FW: 7969/APP/2024/2451 - The Barn Hotel

TfL Reference: HLDN/24/13

Borough Reference: 7969/APP/2024/2451

Location: The Barn Hotel, West End Road, Ruislip, HA4 6JB

Figure 6.4: Vehicle & Cycle Parking

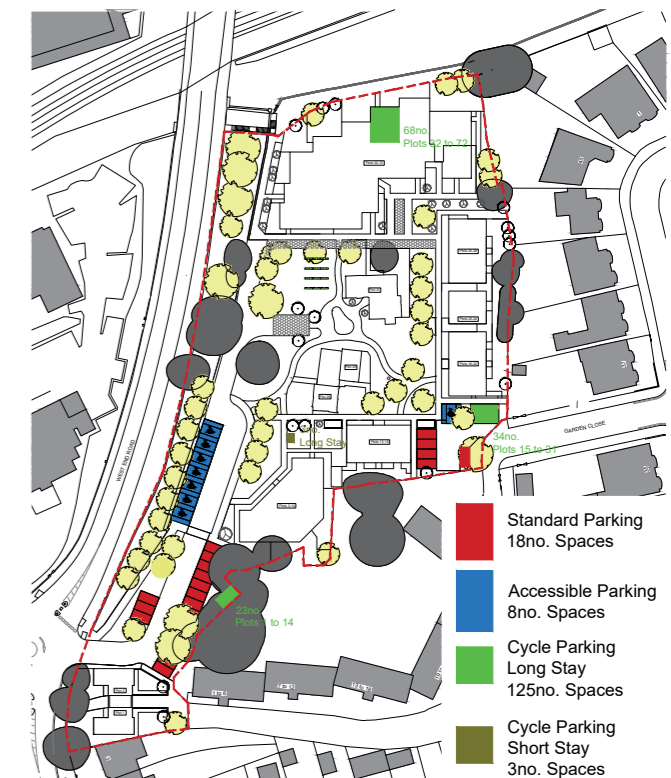
The proposed development provides 125 long-stay cycle parking spaces, which is 1 space more than the 124 required to be in line with London Plan Policy. Long-stay cycle parking is provided in 3 separate secure cycle stores. One cycle store that is for the use of units 1-14 provides 23 spaces, another cycle store for the use of units 15-31 provides 32 spaces, and the final cycle store for units 32-72 provides 68 spaces. Although the quantum of long-stay cycle parking is London Plan compliant, the spread across the cycle stores means that units 32-72 will have an under provision of 3 spaces, which is not compliant with London Plan Policy T5.

In addition, the documents provided have no information regarding the type of cycle parking and whether accessible or enlarged cycle spaces will be provided. London Plan Policy T5 states that *'Development proposals should demonstrate how cycle parking facilities will cater for larger cycles, including adapted cycles for disabled people.'* TfL requests that improved plans highlighting the type of cycle parking are provided prior to determination. The cycle parking should be designed in line with London Cycle Design Standards (LCDS) guidance.

The development proposes 3 short-stay cycle parking, this quantum is in line with London Plan Policy. TfL requests that the short-stay cycle parking is LCDS compliant.
